47.5164.L12A:MSC

**S96 APPLICATION**

**PROPOSED RESTAURANT & BAR**

**BARANGAROO PROJECT**

drawing number
BR1-ASK-13-00-00

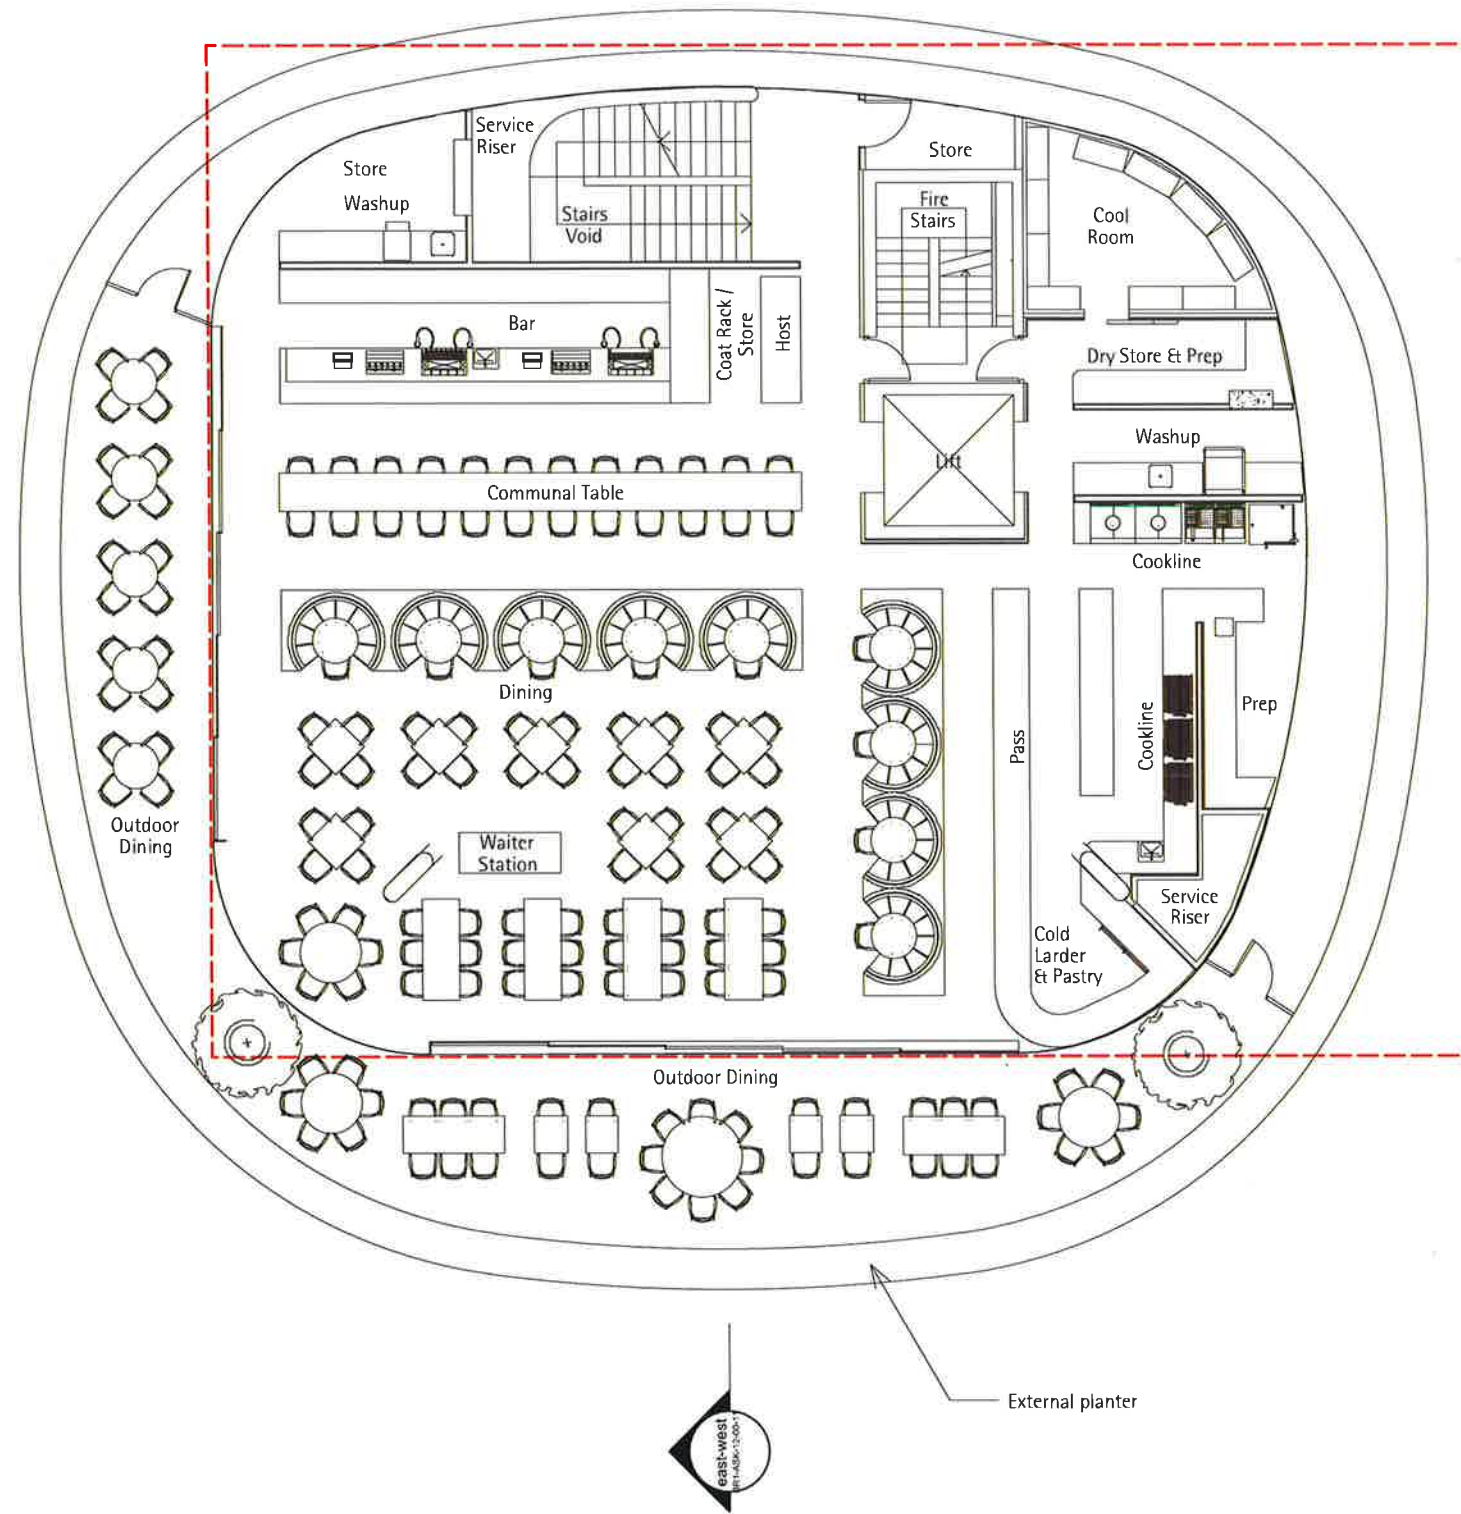
The Collins and Turner drawing BR1-ASK-13-00-00 revision E for the ground floor is to be submitted with the s96 Application. The drawing shows seating for 64 patrons on the northern balcony, 30 patrons on the southern balcony and the remainder on the western balcony. We are advised that the total capacity of the outdoor areas will remain at 230 patrons (i.e. some patrons standing in the outdoor areas when at full capacity).

The drawing also indicates that the former operable wall on the northern side of the ground floor will be fixed glazing.

The s96 application will not alter that contribution from the northern balcony. The noise contribution from the western balcony will be marginally higher but is lower than the northern balcony, whilst the southern balcony contribution will decrease.

In addition, the noise contribution from the internal area of the ground floor that was assessed with the doors open will be reduced because of the proposed fixed glazing on the northern side of the ground floor.

The noise contribution from the ground floor of Building R1 that is proposed in the s96 Application will result in a reduction in noise from Building R1.

Accordingly, the Building R1 will maintain compliance with the acoustic criteria contained in the development consent.
